From: Stuart Morgans
Sent: 22 November 2018 14:46
To: Michael Eastham
Subject: Sport England Response : WA/95/18/RES - Land east of Tye Lane, Walberton - Reserved Matters for 175 dwellings and associated works

The Proposal and Assessment against Sport England's Objectives and the NPPF

LEAP 2 LAYOUT PLAN

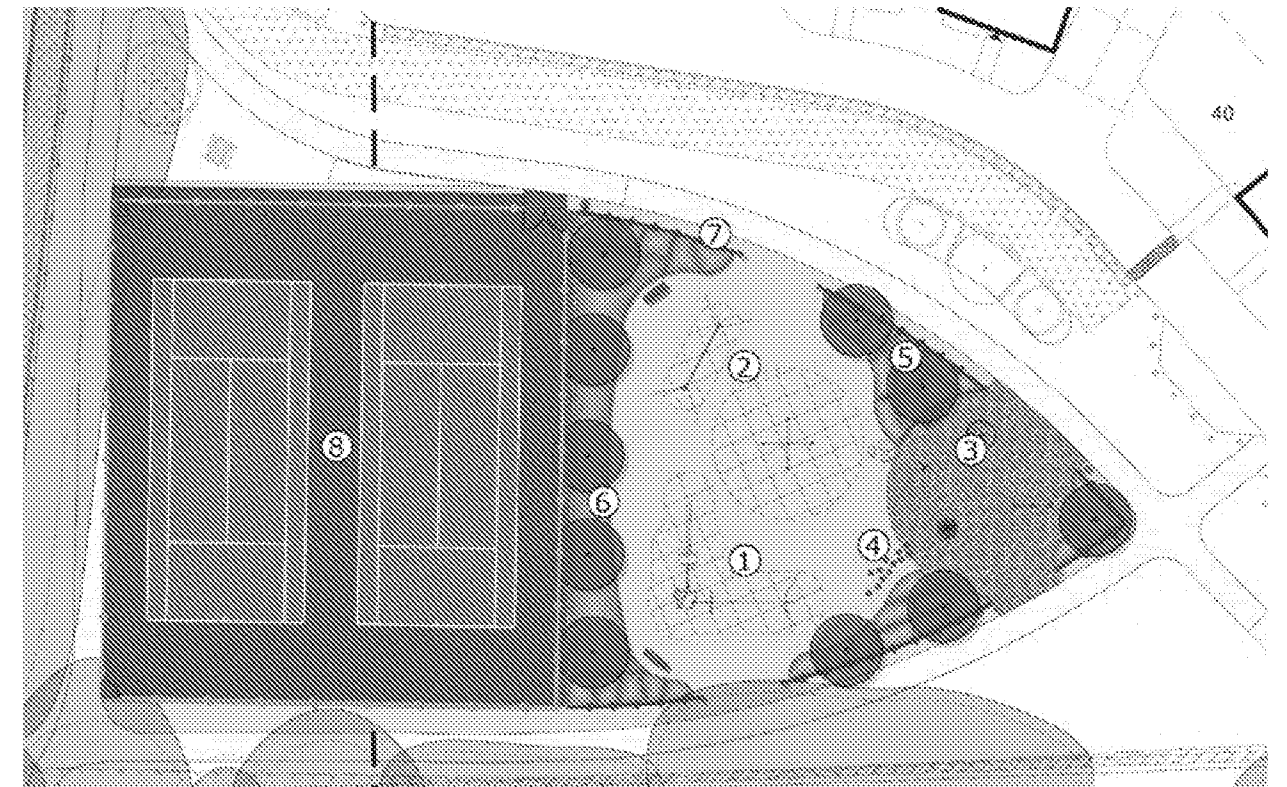
Sport England seeks to ensure the new sports facilities are fit for purpose. There is little detail in the proposed plans to confirm the design and specification of the courts. Whilst they are shown to be of an appropriate size, no details are provided to confirm the proposed surface specification, or associated ball catch fencing details which should be provided. A cross section of the court surface through to the sub-base should also be provided to demonstrate that this accords with the relevant design guidance (see below link). There are no details to confirm whether or not the courts are to be floodlit, but if they are, further details of the floodlighting should also be proposed. Having reviewed the outline decision notice, there does not appear to be an existing planning condition under which these details could be provided, and so it is recommended that either further details are requested to be submitted to be determined as part of this reserved matters application, or the following condition be imposed on the reserved matters consent:

The layout of the development promotes walking and cycling by providing a footpath link from the development to the adjoining playing field, though there is a missed opportunity to provide a direction footpath connection into the adjoining school to promote walking and cycling opportunities for parents and children using these existing community facilities. If such a link could be provided this would further enhance the active design outcomes from this development.

Prior to the commencement of the construction of the tennis courts shown on the approved plans, further details of the design and specification of the tennis courts playing surface and sub-construction, associated ball catch fencing, and any floodlighting (where floodlighting is to be provided) have been submitted to and approved in writing by the Local Planning Authority in consultation with Sport England. The tennis courts shall not be constructed other than in accordance with the approved details and shall be made available for use prior to the first occupation of plots 36-40 (inc).
